Rezoning Petition Review

From: Doug Lozner

Date of Review: December 29, 2020

Rezoning Petition #: 20-160

**Aldersgate Rezoning #2020-\_\_\_**  
3800 Shamrock Drive  
Charlotte, NC 28215  
Date: 10/02/2020 Rezoning Submittal  
Project ID: 17048  
**Proposed Rezoning Technical Plan**  
**RZ-01**

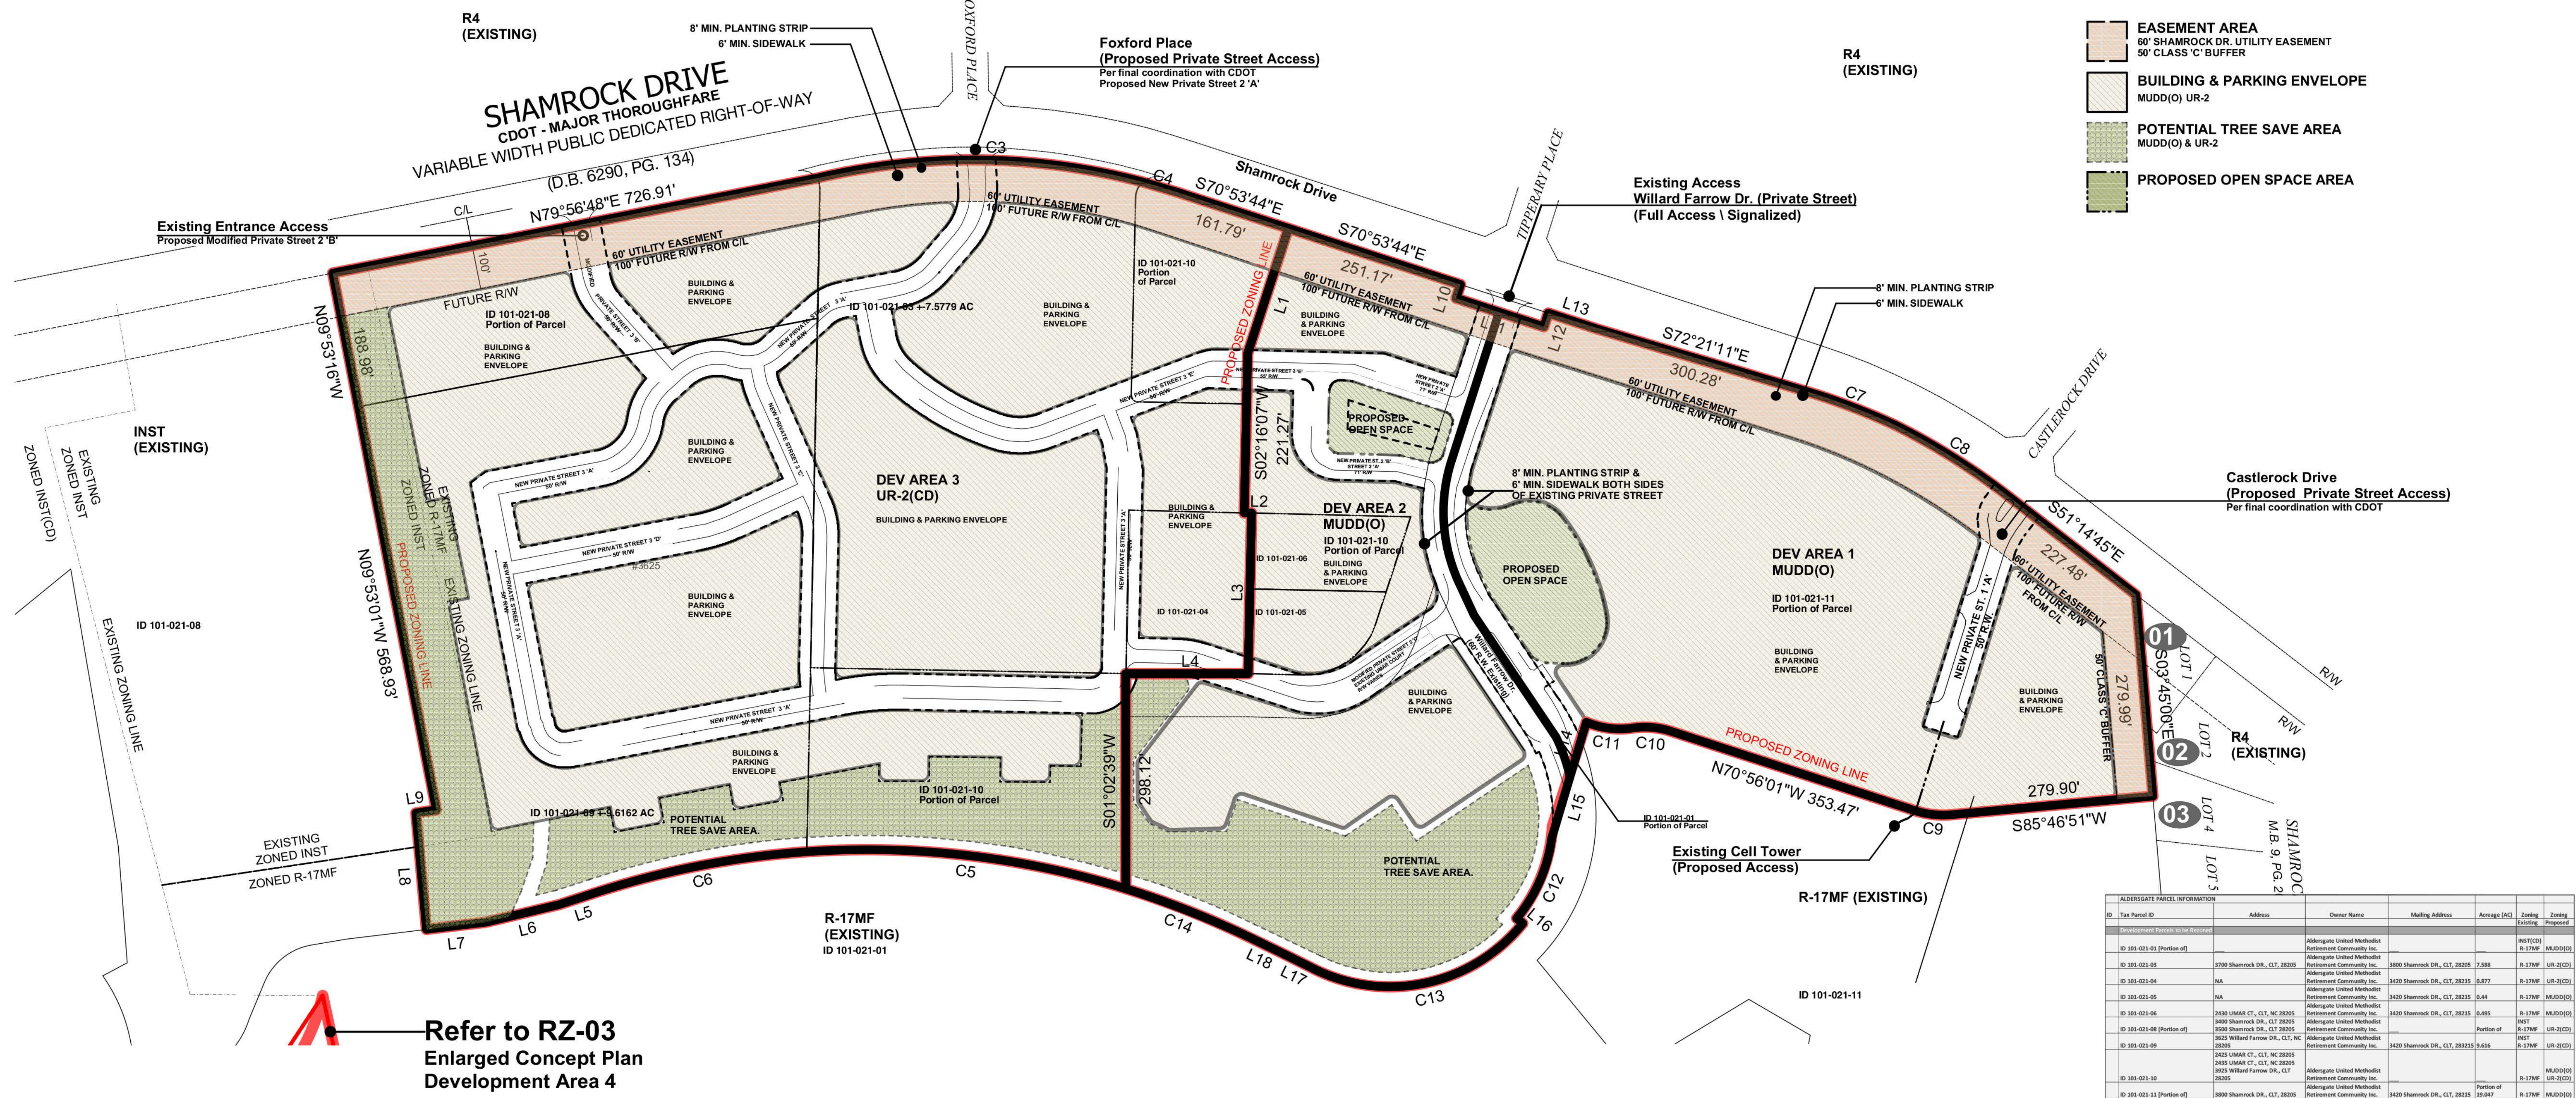
Recommendations Concerning Storm Water: City of Charlotte GIS data indicates a 30-ft PCSO buffer and 50-ft PCSO/SWIM across the site. Please show and label *Potential 30-ft PCSO Buffer* and *Potential 50-ft SWIM/PCSO Buffer* on the site plan. Any increase of impervious area within such buffers may not be allowed and is not approved with the rezoning process. Stream Delineation Reports are subject to review and approval by Charlotte Storm Water Services.
